Ribble Valley Borough Council  
Housing & Development Control

Application no: **3/2023/0065**

Address: **41 Dilworth Lane Longridge PR3 3ST**

Proposal: **Access to proposed single dwelling reduced in width and moved to the east to avoid telegraph pole and lamp post. Previous approval 3/2016/1201.**

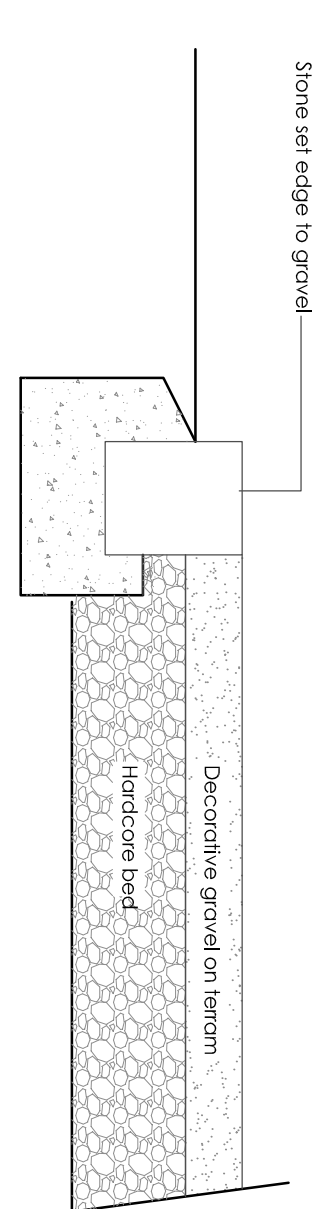
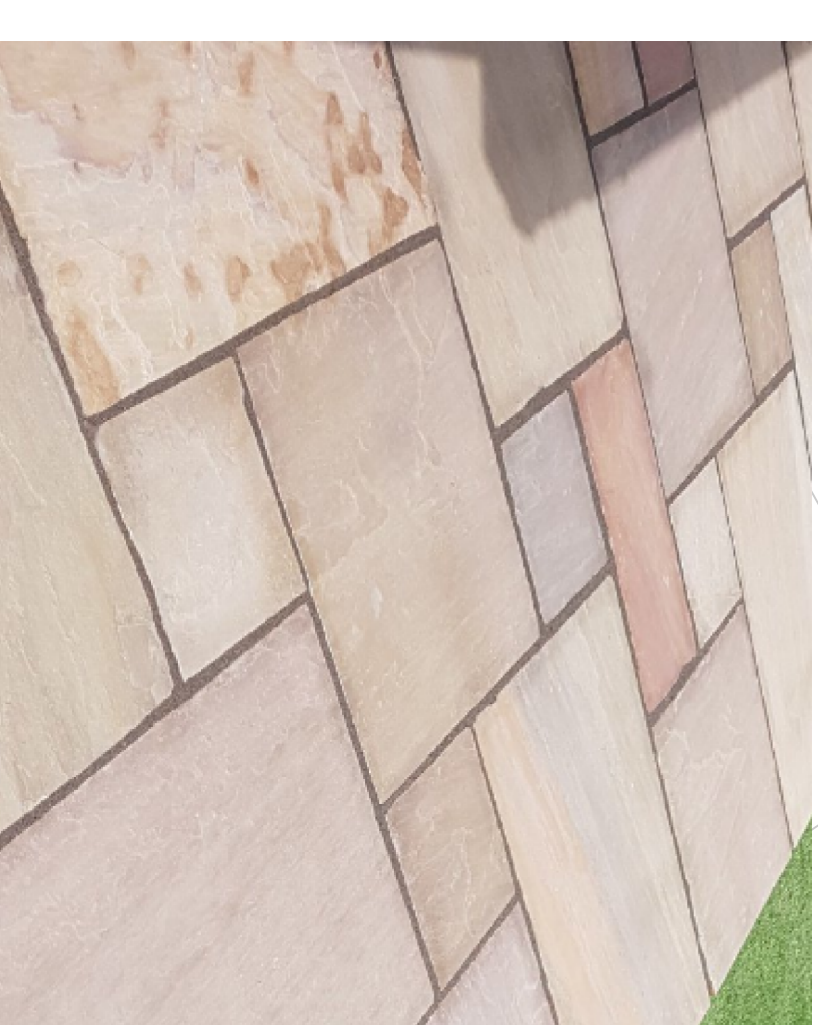
The LHA have reviewed SPA drawing number 4892-P02D titled "Proposed Site Plan-Finishes" and the other supporting documents and are aware that the number of bedrooms and the parking arrangements at the site will remain unaltered. Therefore, the LHA have no comments to make regarding the internal layout of the site.
